From: Martin Hill <Martin.Hill@arun.gov.uk>
Sent: 03 November 2020 18:41
To: Planning.Responses <Planning.Responses@arun.gov.uk>
Subject: RE: Planning Consultation on: LU/295/20/PL

Comments from Private Sector Housing:

Application No: LU/295/20/PL

Description of Works: Full planning application incorporating permitted change of use of part of existing office (A2 Professional & Financial Services) & use to form 2 No. dwellings (C3 Dwelling houses) on the two upper floors (resubmission following LU/107/20/PL). This site is in CIL Zone 4 (Zero Rated) as flats.

SCALE / 1:100 @ A3
DATE / 30.03.2020
DWG. NO / 080616/TP.02.REV. 'C'

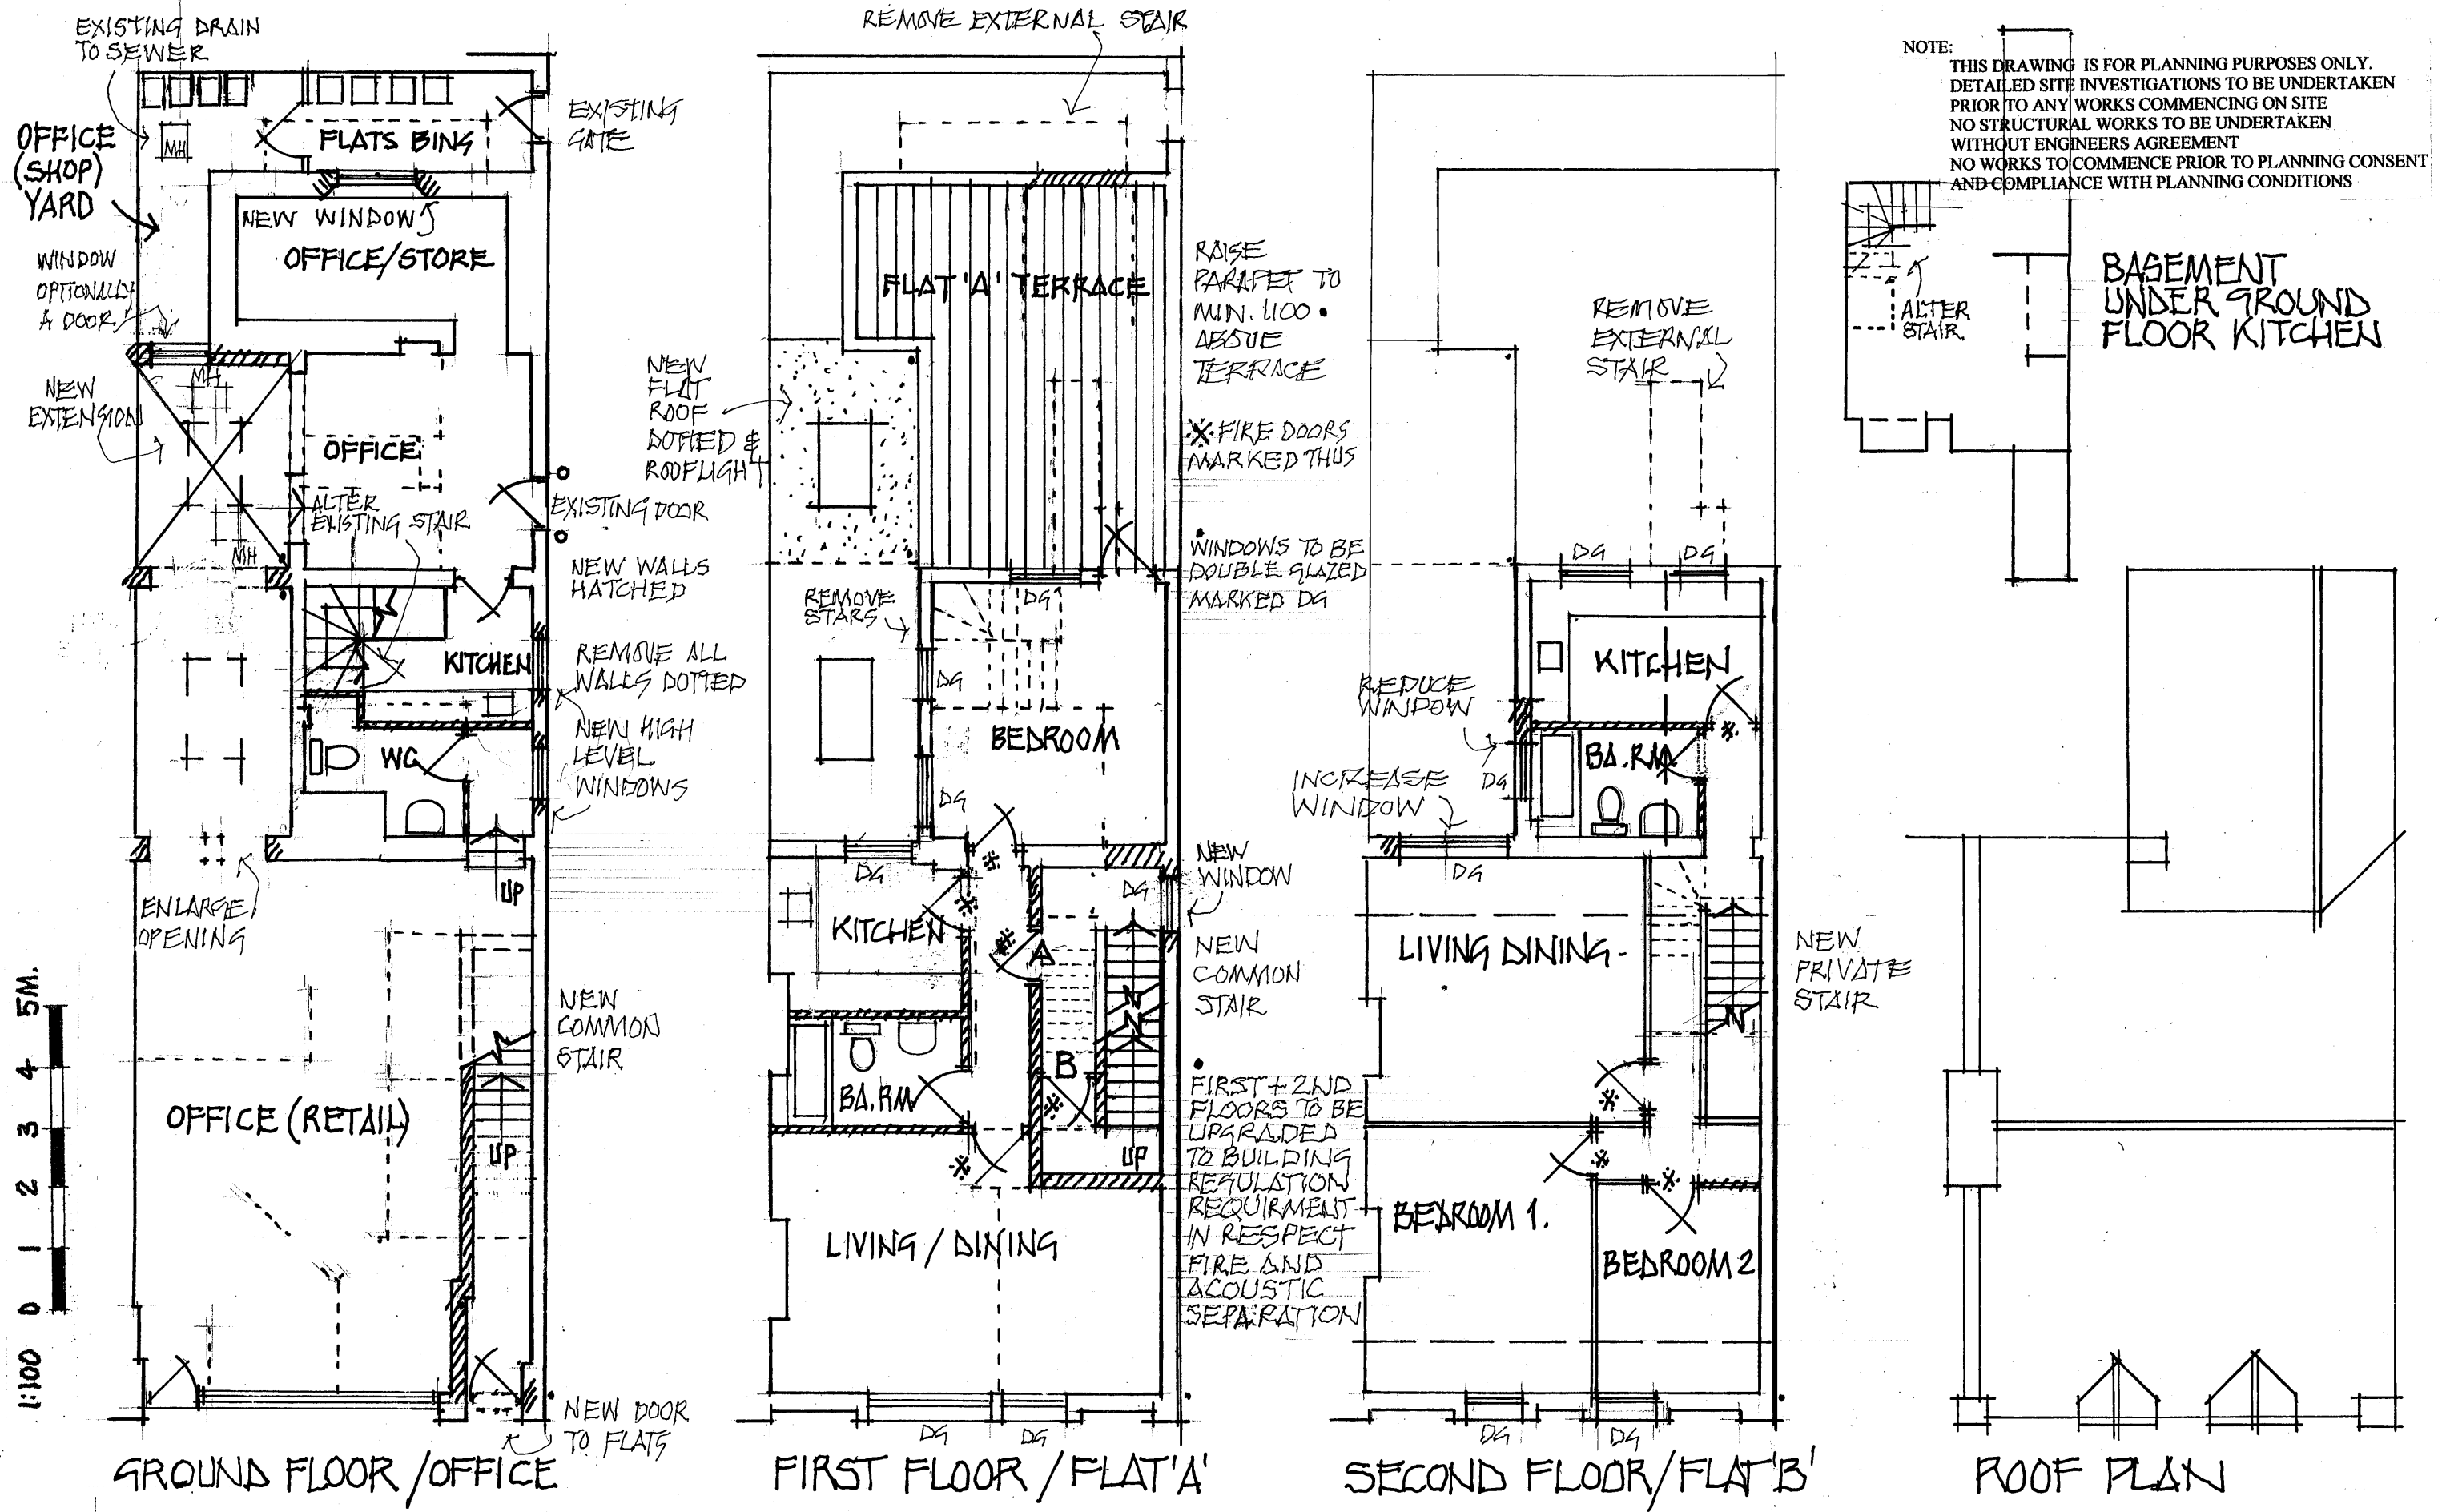
- There should be adequate fire separation between the commercial unit on the ground floor and the residential flats above.
- There should be a minimum 30 minutes fire resistance between the basement and ground floor, including a 30 minute fire-resisting door.

- 30 minute fire resisting escape route, which would include providing a 30 minute fire resisting and self-closing fire door conforming to FD30S standard (includes intumescent strips, cold smoke seals, 3 fire-rated hinges and an overhead self-closing device) to each flat entrance door.

- Compartment walls, ceilings and doors must provide a minimum of 30 minutes fire resistance in order to protect the common means of escape.
- As a minimum, each kitchen/dining area and bedroom in each flat must be fitted with a close-fitting conventional door in order to protect the means of escape and provide for privacy in bedrooms.

- Any windows on the first floor with a sill height of less than 1100mm should be fitted with window opening restrictors, which have an override facility. The opening should be restricted to not more than 100mm.
- The windows in Flat B, on the second floor, should be fitted with window opening restrictors, restricting the opening to not more than 100mm.

- The railings proposed for the perimeter of Flat A Roof Terrace on first floor level must be a minimum of 1100mm in height, with any gaps in the railings not allowing a 100mm sphere to pass through it.
